re: Hydrogeological Response to City Comments
Proposed Industrial Redevelopment
135 Cardevco Road – Carp - Ontario

date: May 16, 2023

file: PH4600-MEMO.02

Further to your request and authorization, Paterson Group (Paterson) prepared the following memorandum to provide responses to the hydrogeological-related comments from the City of Ottawa listed in the letter dated March 14, 2023 (File No. D07-12-22-0173) regarding the proposed industrial redevelopment at the aforementioned site. This memorandum should be read in conjunction with Paterson Hydrogeological Report PH4600-1-REV.01 dated May 16, 2023.

Drawing No.:
PH4600-2(rev.1)

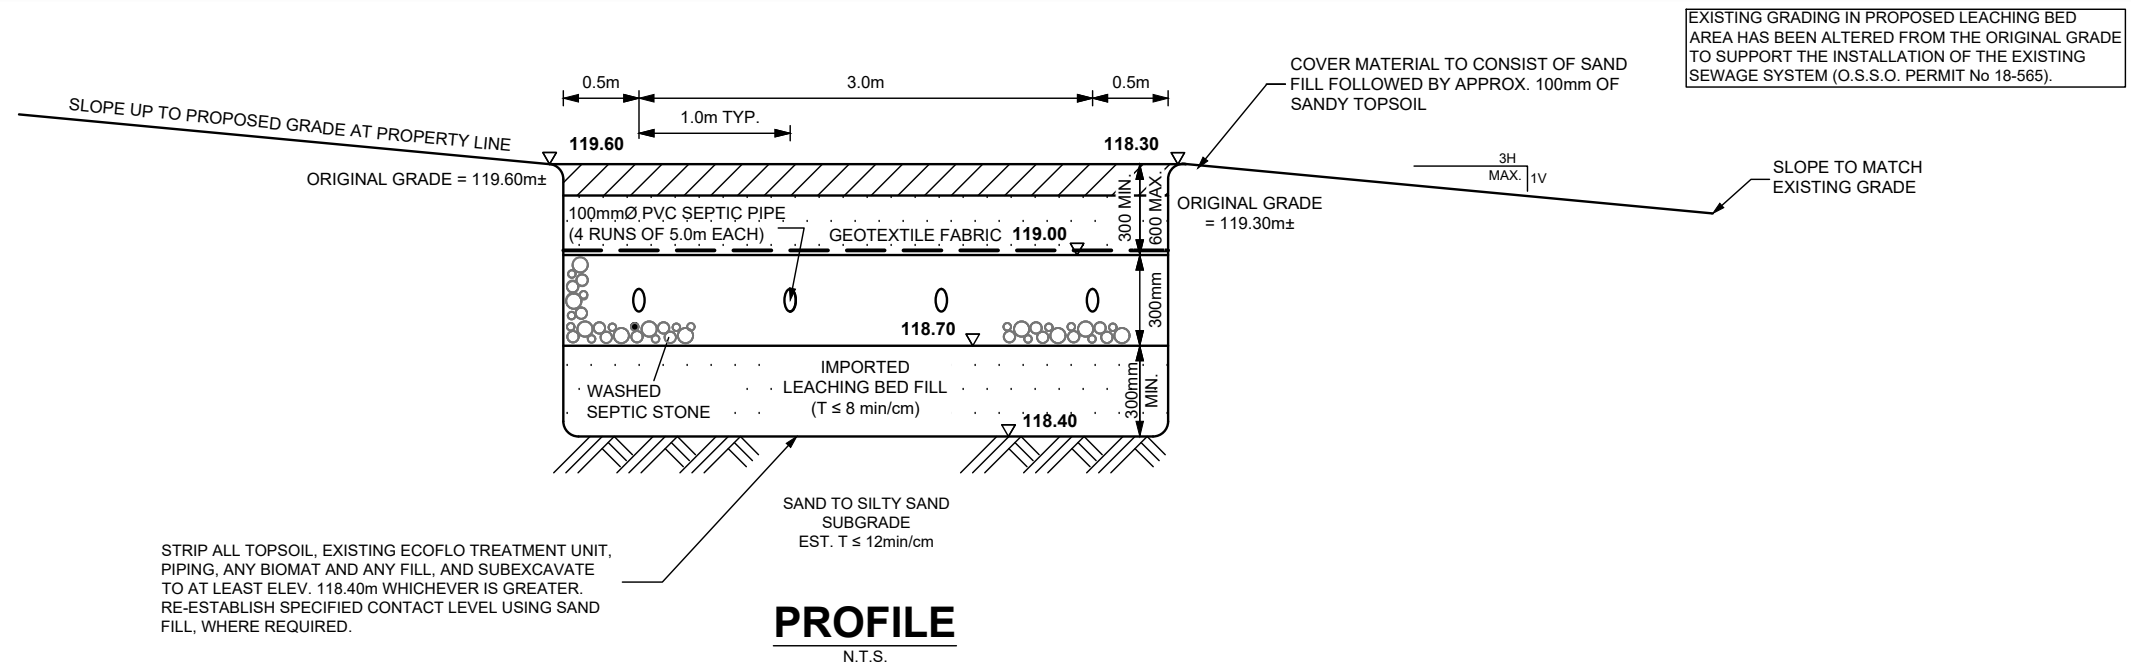
No infiltration/percolation testing was provided for SWM & septic field design, due to a highly vulnerable aquifer and groundwater recharge area present on site, as advised/informed during the pre-application consultation.

The septic field design and supporting documentation is reviewed and approved by the Ottawa Septic System Office (OSSO) as per requirements of Part 8 of the Ontario Building Code. The associated T-time was assessed, reviewed and approved per standard practice of OBC by the OSSO, which reviews sewage system designs on behalf of the City of Ottawa. Additionally, having a highly vulnerable aquifer (HVA) or a groundwater recharge area (GRA) mapped onsite is related to Source Water Protection and has no restrictions related to placement of a sewage system within either of those areas. The requirements for Infiltration / percolation testing for SWM are to be addressed by the SWM engineer.

Drawing	SEWAGE SYSTEM LAYOUT PLAN
Scale:	1:200
Date:	10/2022
Drawn by:	HV
Checked by:	MK
Drawing no.:	PH4600-1(rev.1)

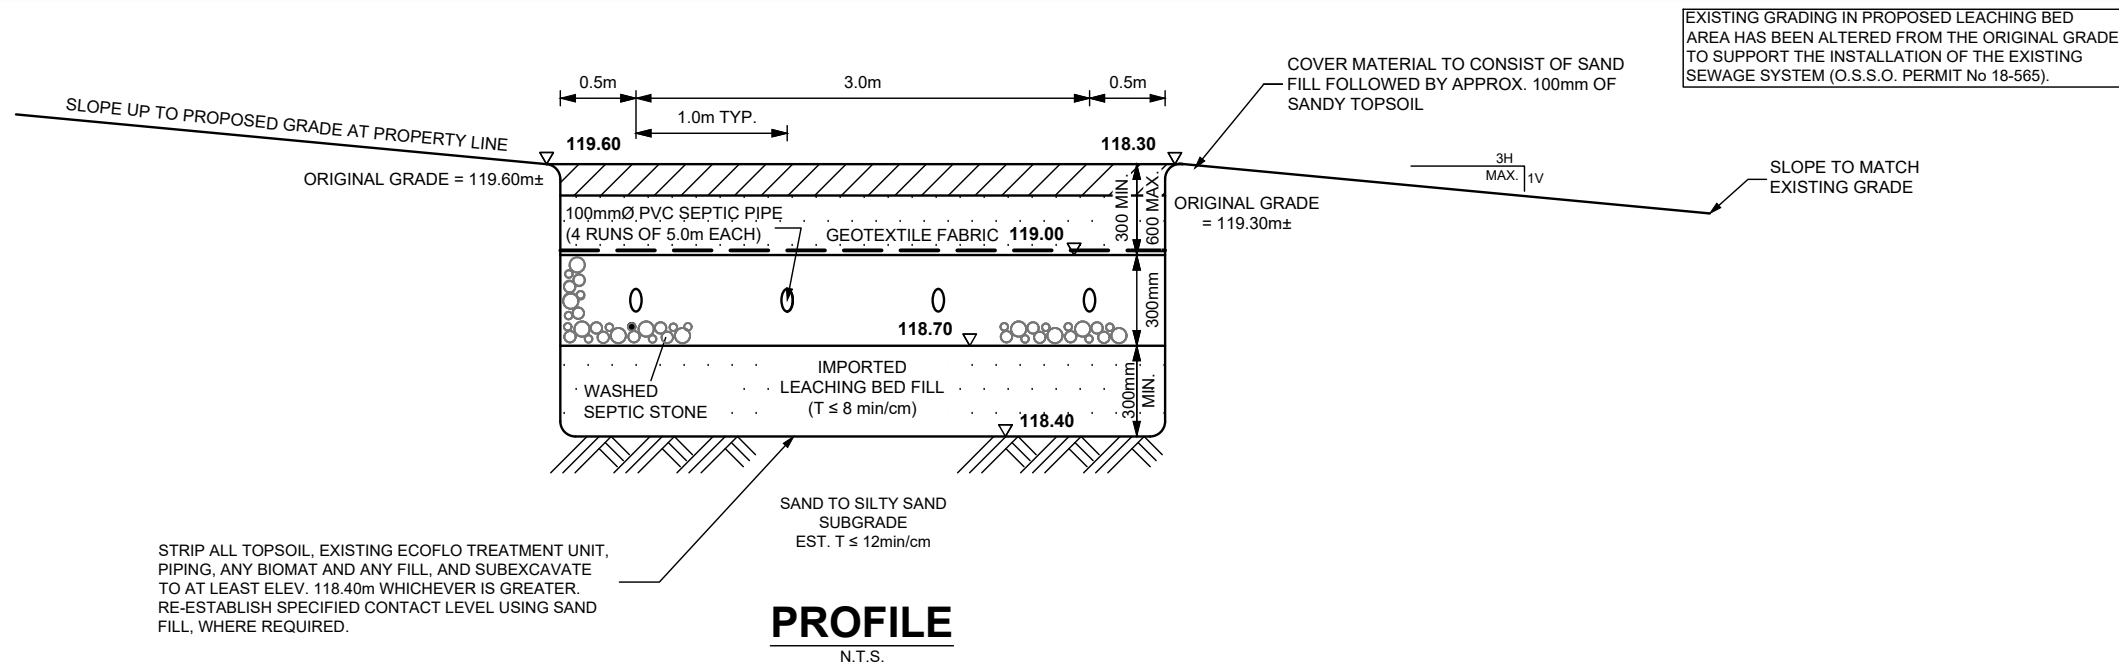
No boreholes have been provided in the area near the proposed septic bed and GWT elevation might be of concern due to highly vulnerable aquifer onsite; infiltration and long-term groundwater protection might be of concern and this relates to the Hydrogeological terrain analysis findings based on the geotechnical investigation.

A sewage system design and associated application for a Ottawa Septic System Office (OSSO) sewage system installation permit will be submitted to the OSSO. The OSSO is a regulatory body which the City of Ottawa has retained for permitting purposes and is managed by the Rideau Valley Conservation Authority, for the precise purpose of regulating the sewage system application process in Ottawa. The HVA is noted under the Mississippi-Rideau Source Protection Plan and there are no restrictions related to placement of sewage systems within an HVA. The system has been designed to be in compliance with Part 8 – OBC.
